CITY OF ALBUQUERQUE

February 13, 2017

Re: St Martins Hospitality Center Paving Project
1120 Second St.
Traffic Circulation Layout
Engineer's Stamp 02-03-17 (J18-D182)

ENGINEER'S SEAL  3/21/17 DAVID SOULE P.E. #14522	ST. MARTINS		DRAWN BY WCHJ
	TRAFFIC CIRCULATION LAYOUT		DATE 3-21-17
	 1606 CENTRAL AVENUE SUITE 201 ALBUQUERQUE, NM 87106 (505) 872-0999		21703-LAYOUT-1-19-17
			SHEET # — JOB # 21703

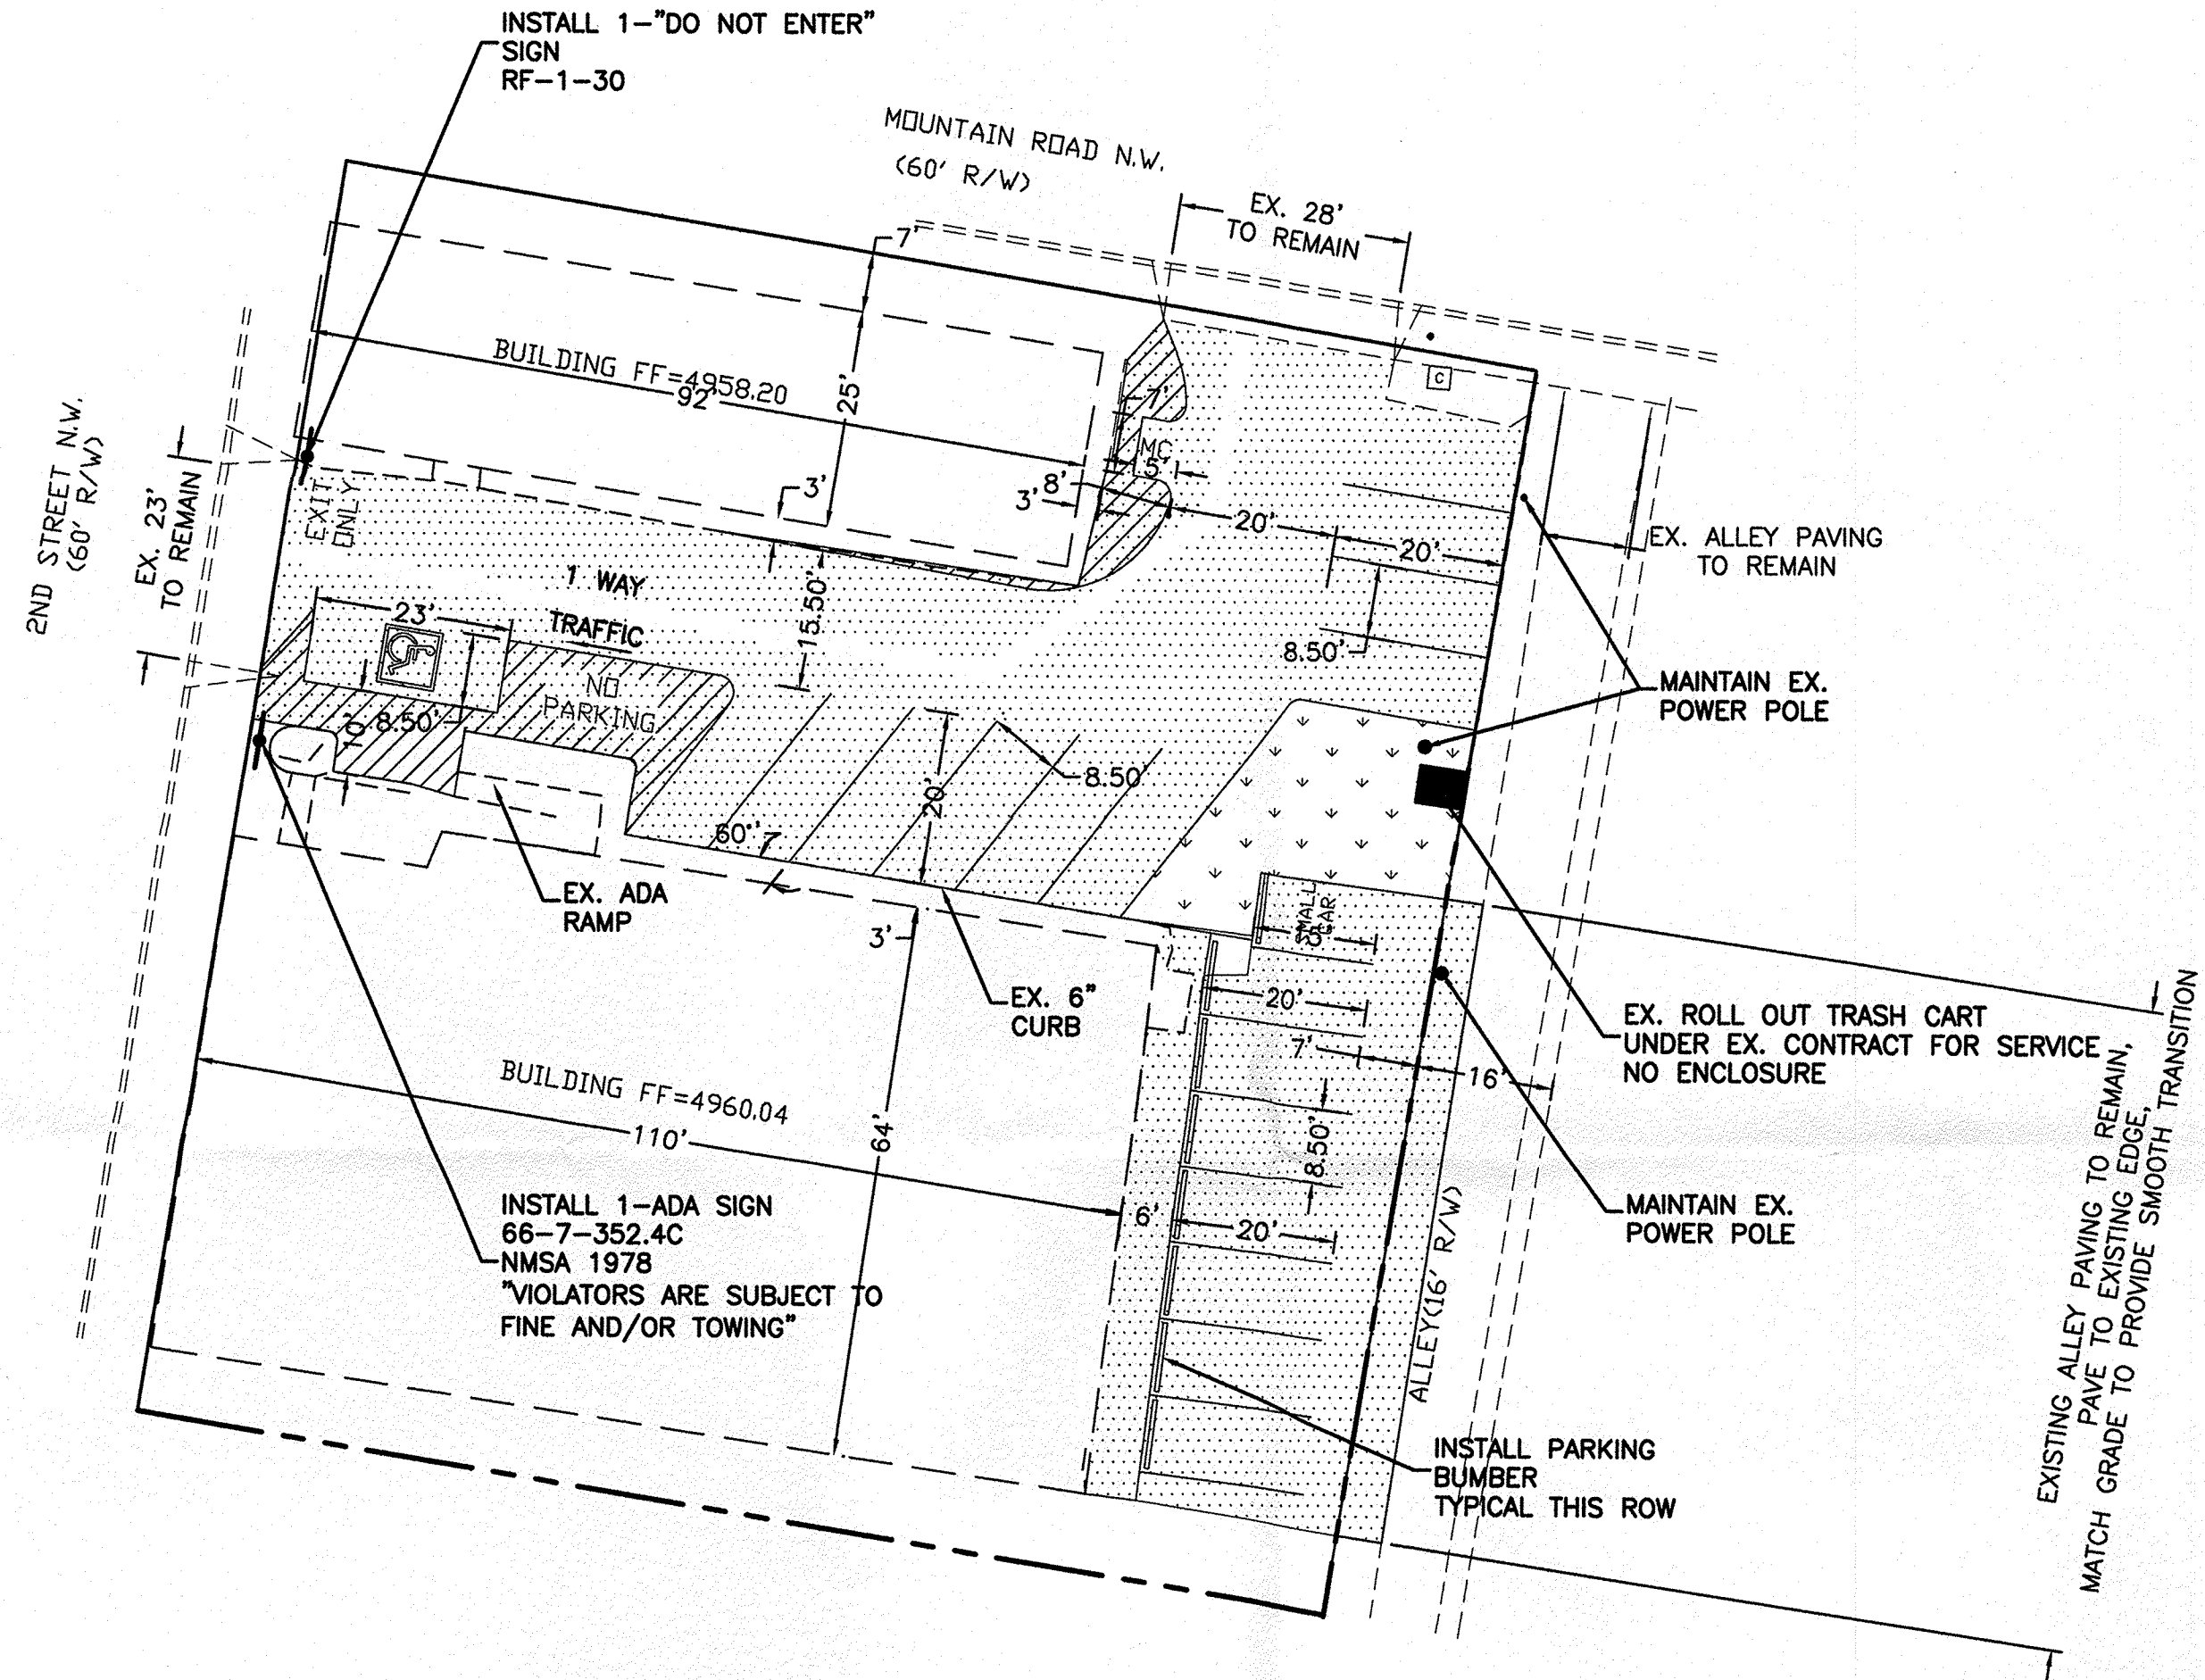
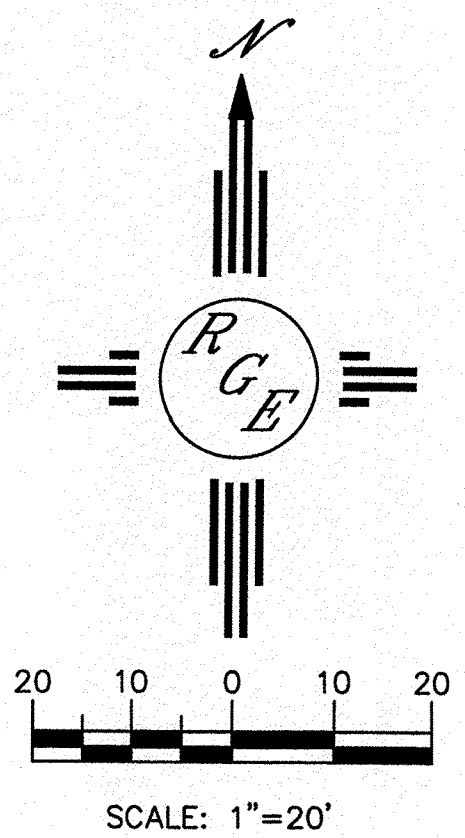
1. List the number of parking spaces required by the zoning code as well as the proposed number of parking spaces including bicycle and motorcycle parking.

2. Label the compact parking spaces by placing the words "**COMPACT**" on the pavement of each space.
3. The ADA accessible parking sign must have the required language per 66-7-352.4C NMSA 1978 "**Violators Are Subject to a Fine and/or Towing.**" Please call out detail and location of HC signs.

4. The ADA access aisles shall have the words "**NO PARKING**" in capital letters, each of which shall be at least one foot high and at least two inches wide, placed at the rear of the parking space so as to be close to where an adjacent vehicle's rear tire would be placed. (66-1-4.1.B NMSA 1978)

ENGINEER'S SEAL	ST. MARTINS	DRAWN BY WCWJ
	TRAFFIC CIRCULATION LAYOUT	DATE 2-03-17
2/3/17	 Rio Grande Engineering 1806 CENTRAL AVENUE SUITE 201 ALBUQUERQUE, NM 87106 (505) 872-0998	21703-LAYOUT-1-18-17
DAVID SOULE P.E. #14522		SHEET # JOB # 21703

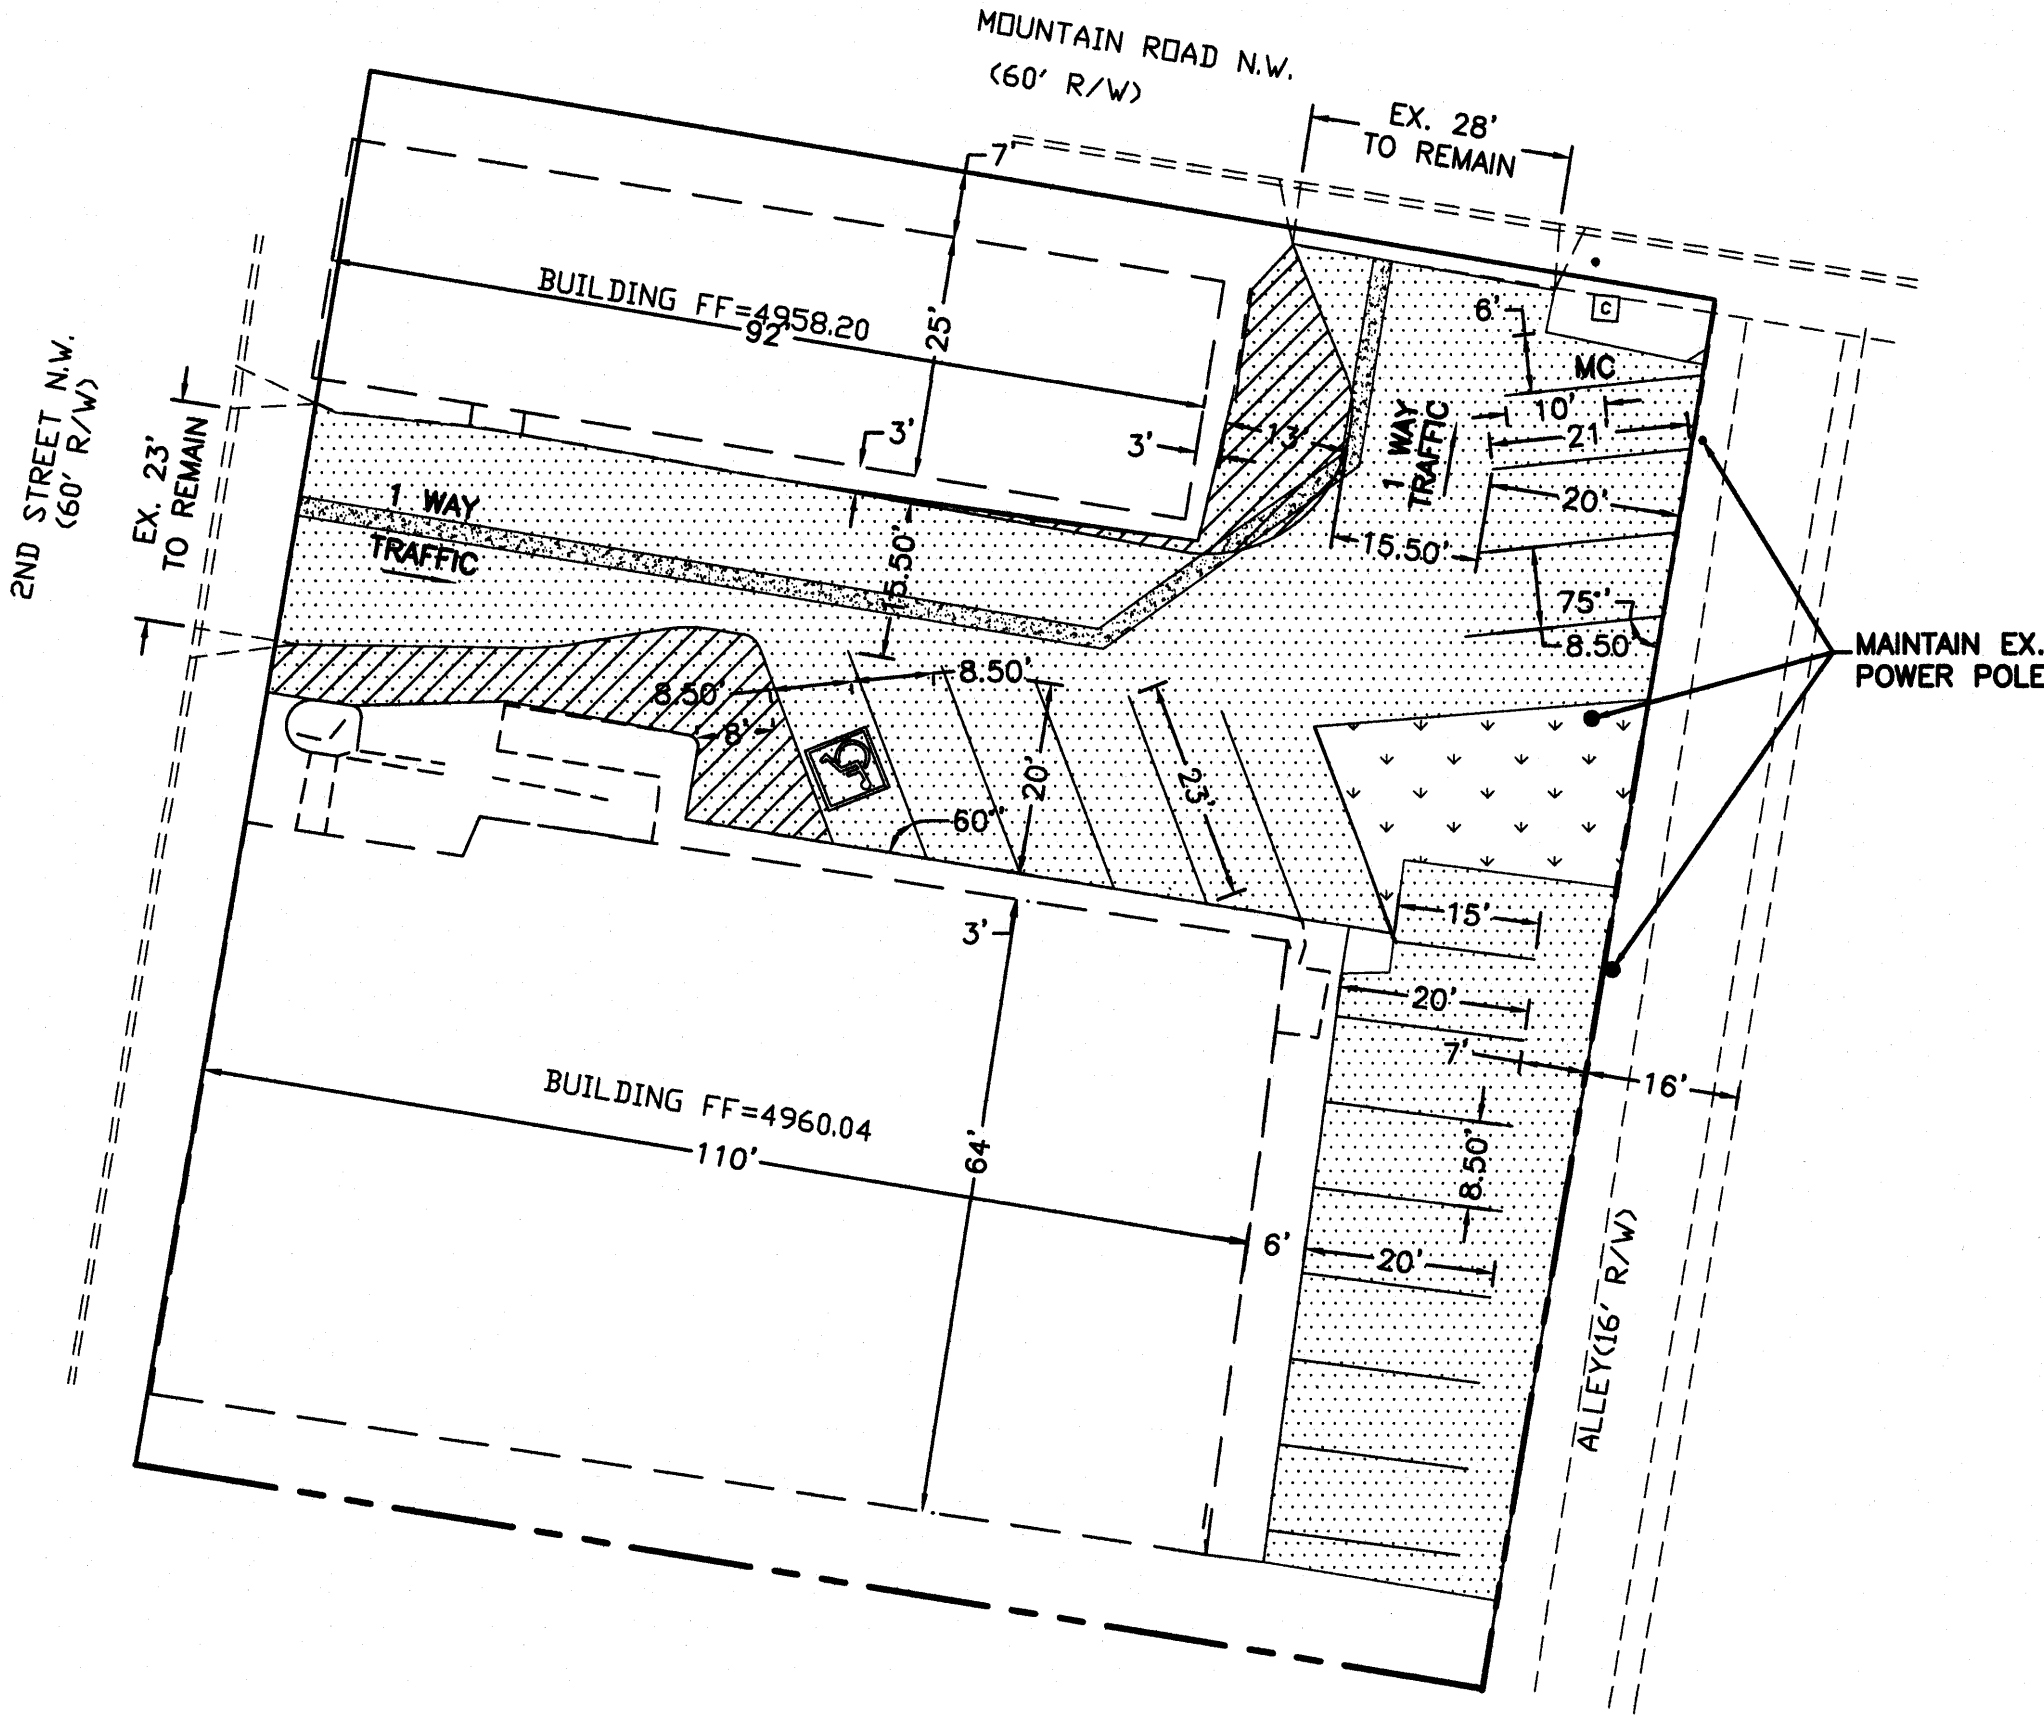
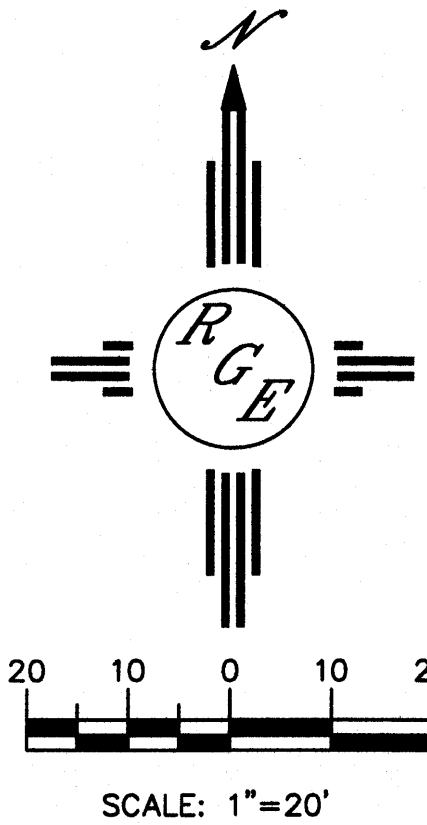
5. Per DPM, a 6 ft. wide ADA accessible pedestrian pathway is required from the HC parking stall access aisles to the building entrances. Please dimensions showing.

6. Provide a min 6" or max 8" high concrete barrier curb or other acceptable barrier between landscaping and parking areas and/or drive aisles. Please call out detail and location of barrier curb.

7. Service vehicle and/or refuse vehicle maneuvering must be contained on-site; provide a copy of refuse approval.
8. One-way vehicular paths require pavement directional signage and a posted "**Do Not Enter**" sign at the point of egress. Please show detail and location of posted signs.

9. The alley off of Mountain Rd NW should be paved. *STD DWG 2411 LP 02/14/2017*
